22 FREE STREET

Thanks for working through this with me and answering my questions last week. Please find attached revised documents addressing your previous comments for clarification:

AD.101 - 22 FREE STREET DEMO FLOOR PLANS
A.101 - 22 FREE STREET PROPOSED FLOOR PLANS

DRAWING TITLE:
AD.101 22 FREE STREET - DEMO FLOOR PLANS

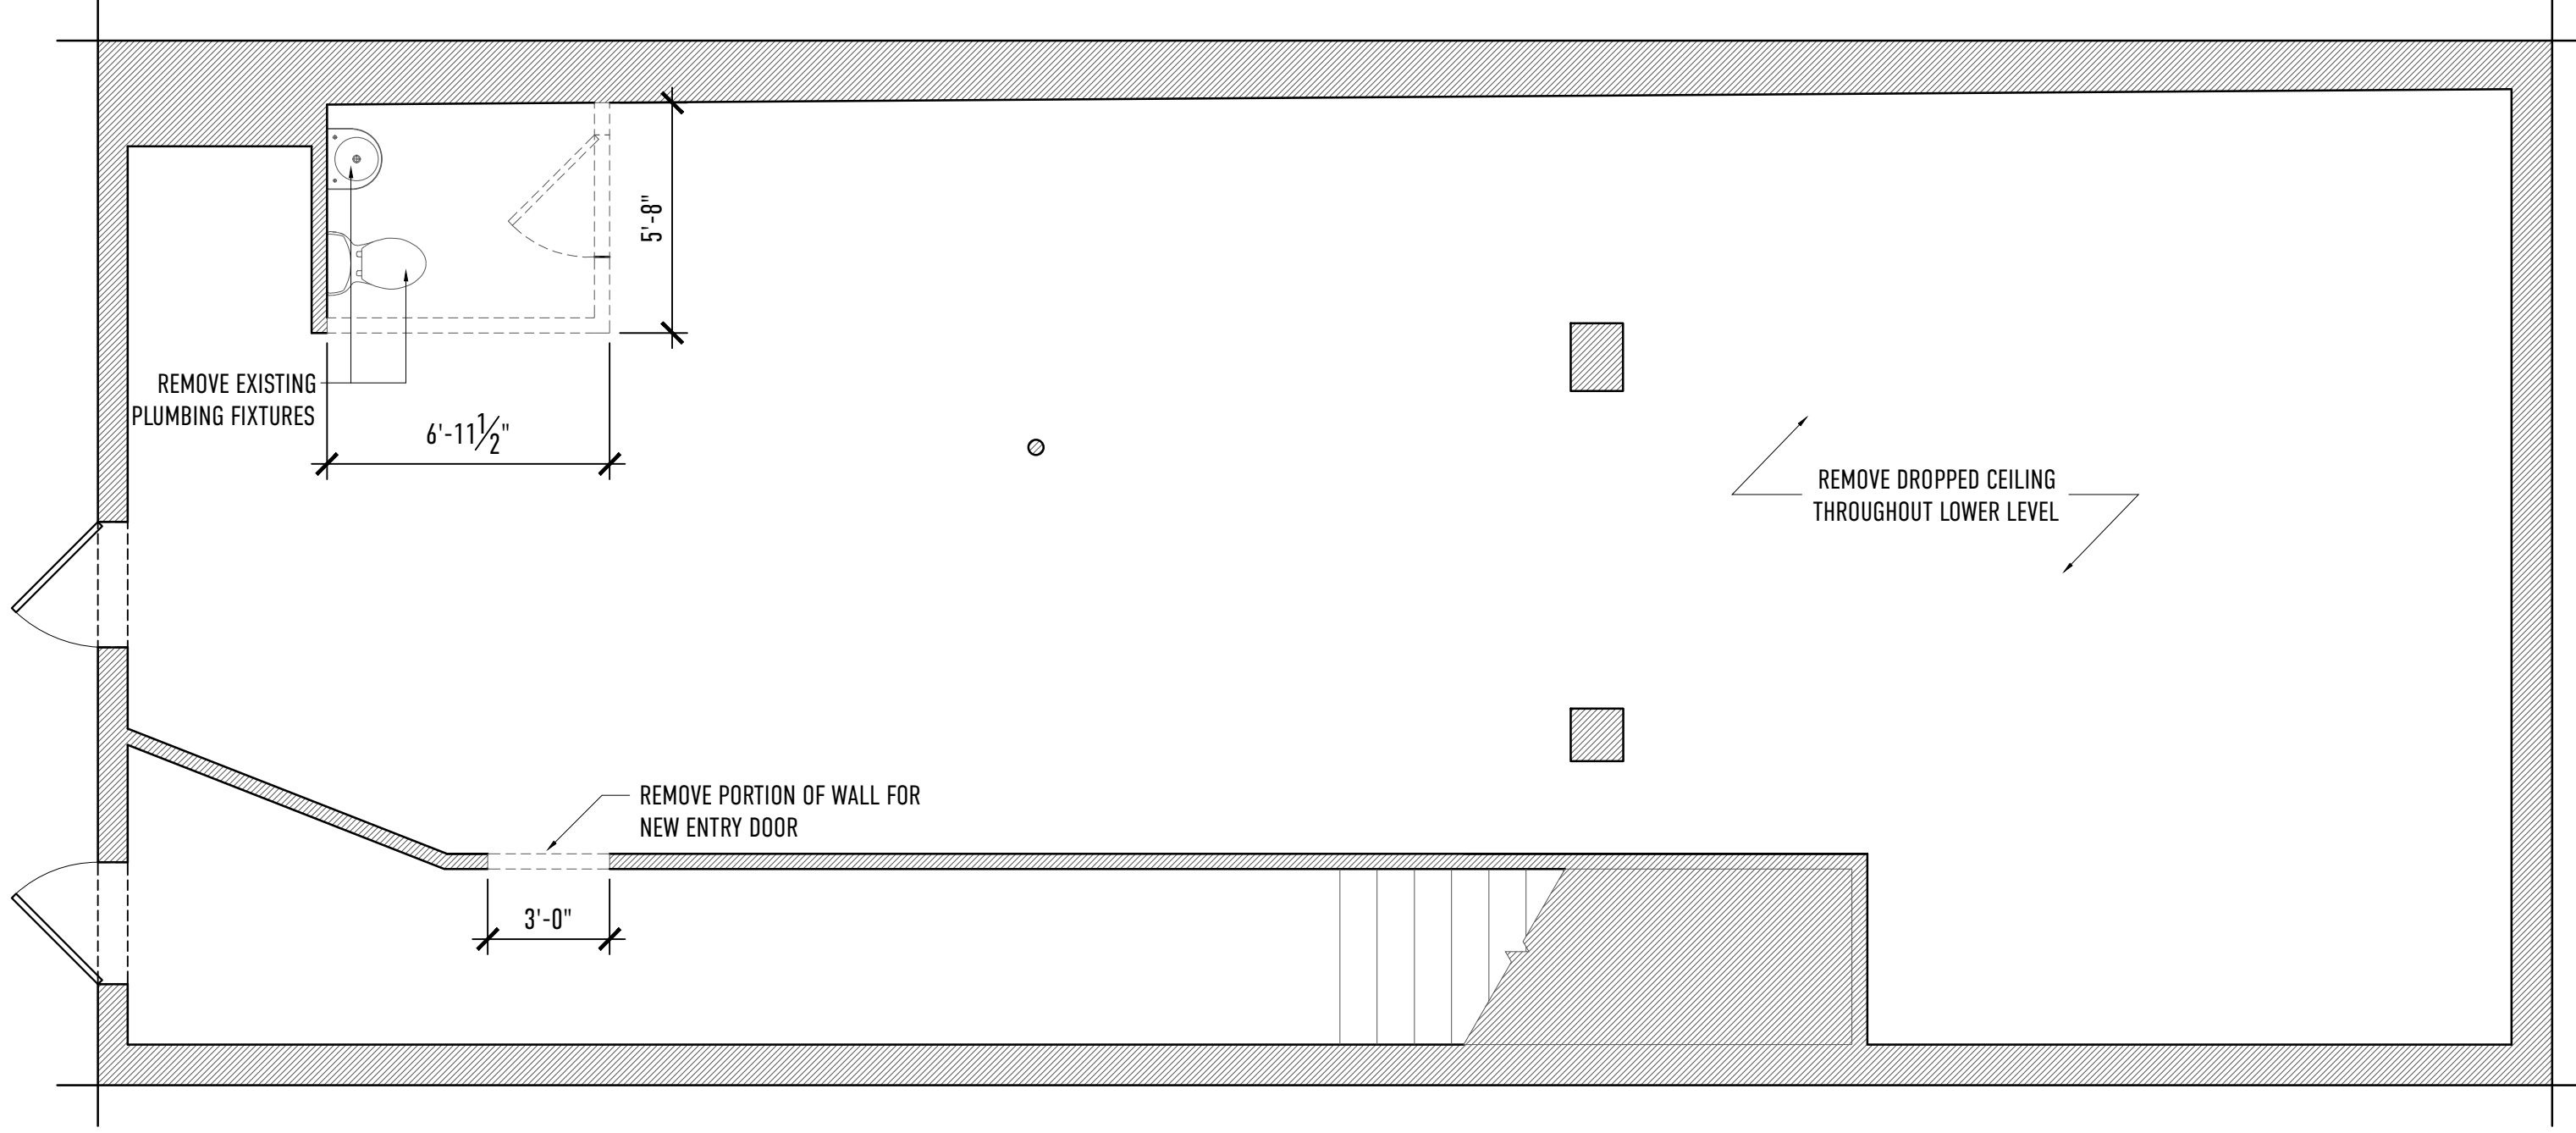
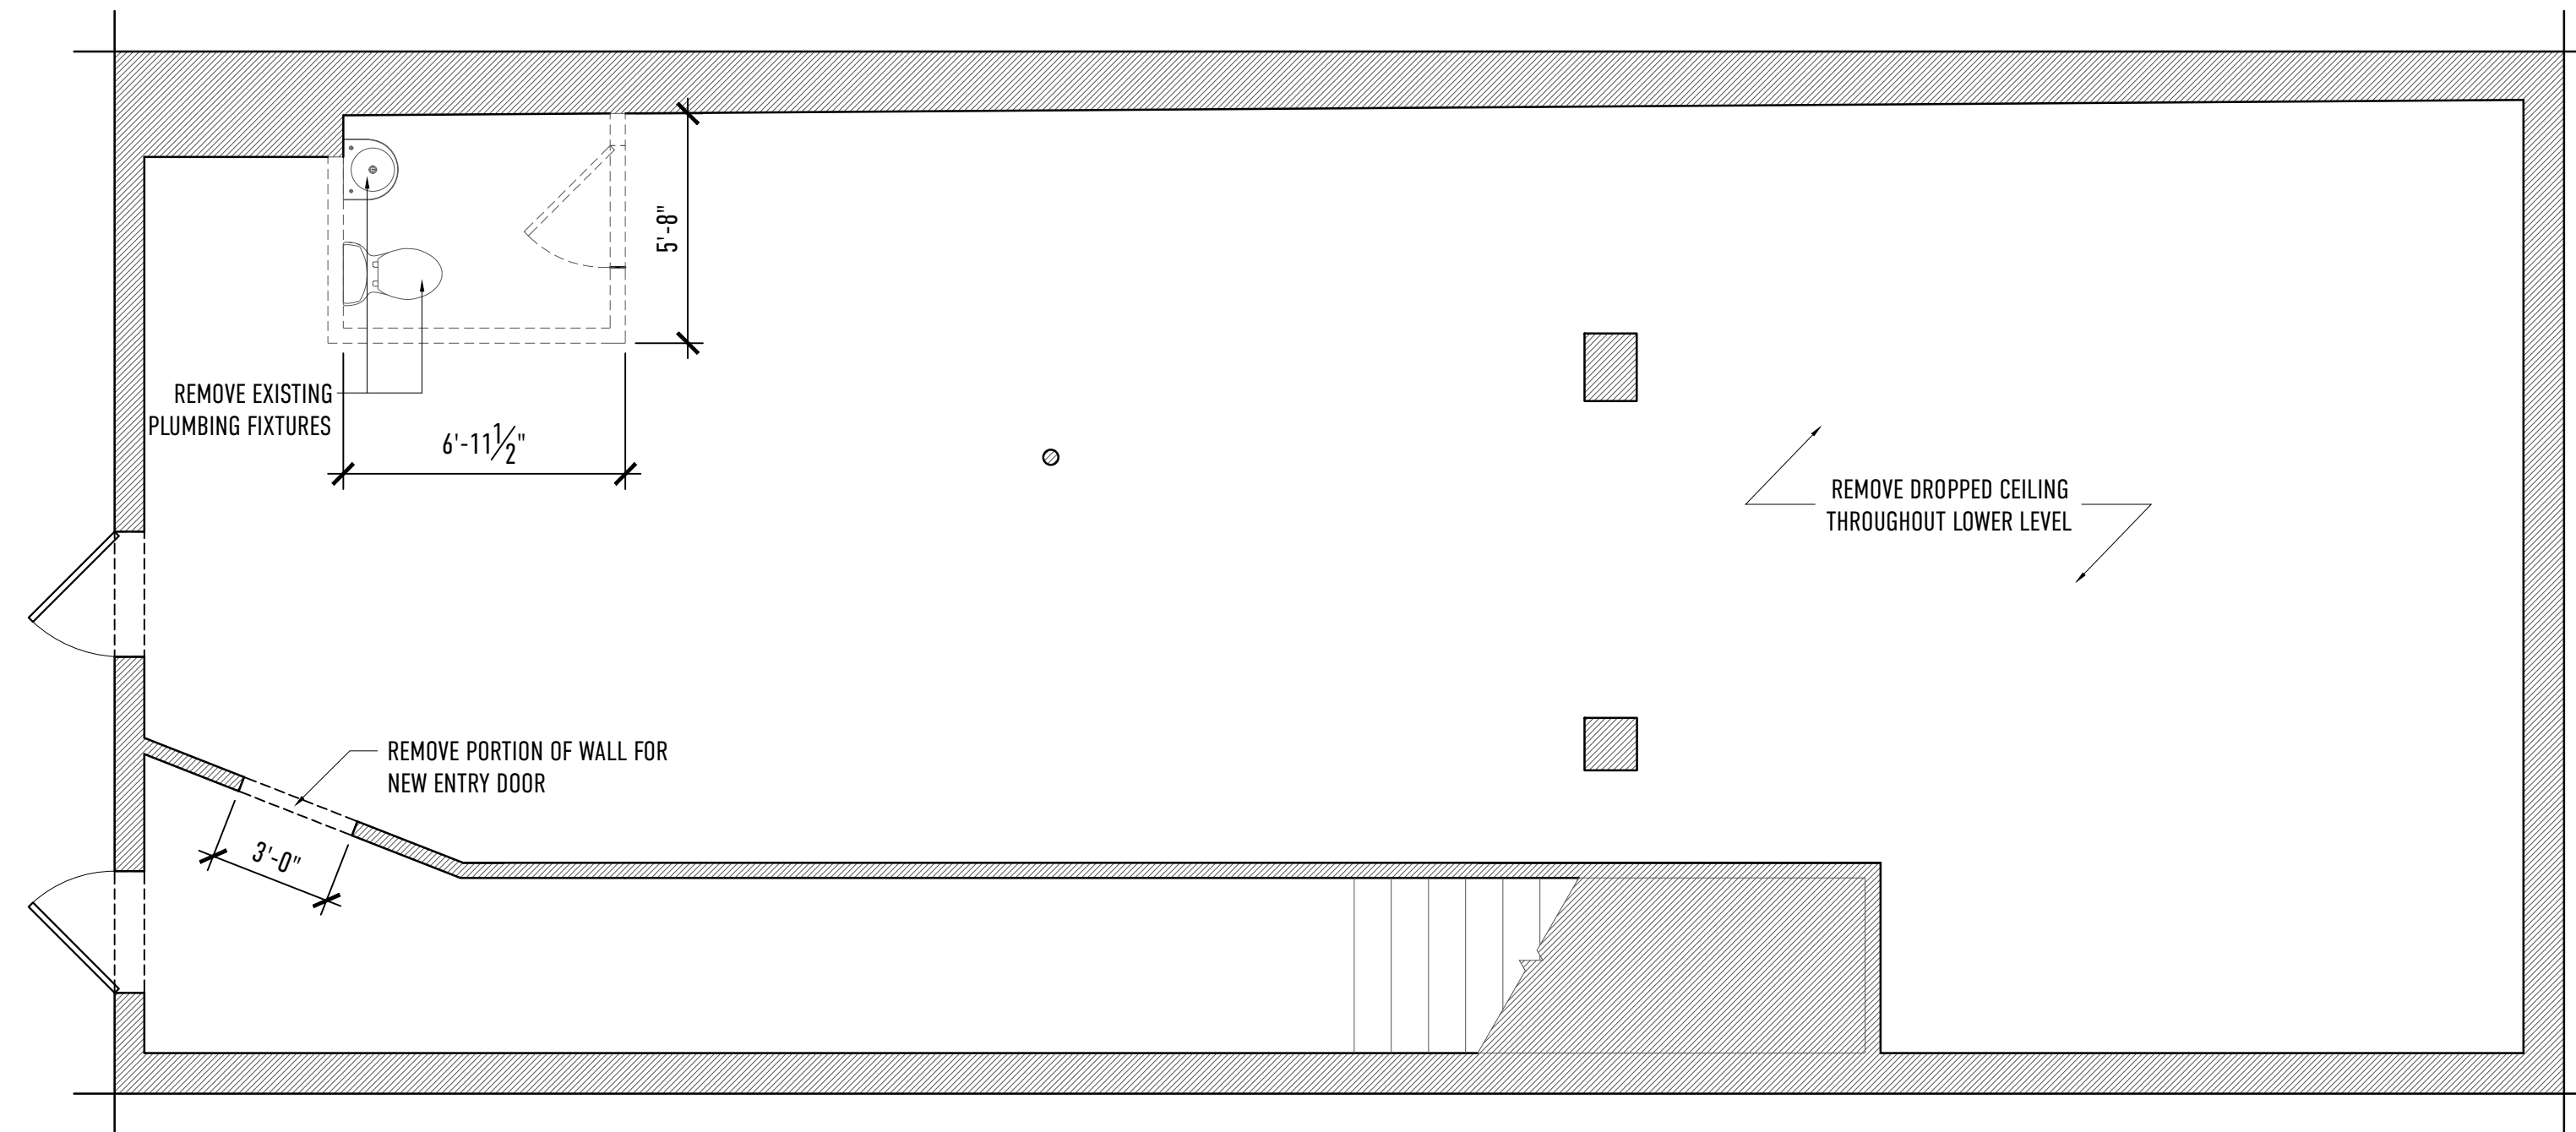
AD.101:

- Dashed lines represent existing granite sill to remain.
- Please see updated 'General Notes' for questions on plumbing/sanitation, sprinkler, floor structures, and existing finishes.
- New entry door has been relocated along non-load bearing wall - header is non-load bearing.
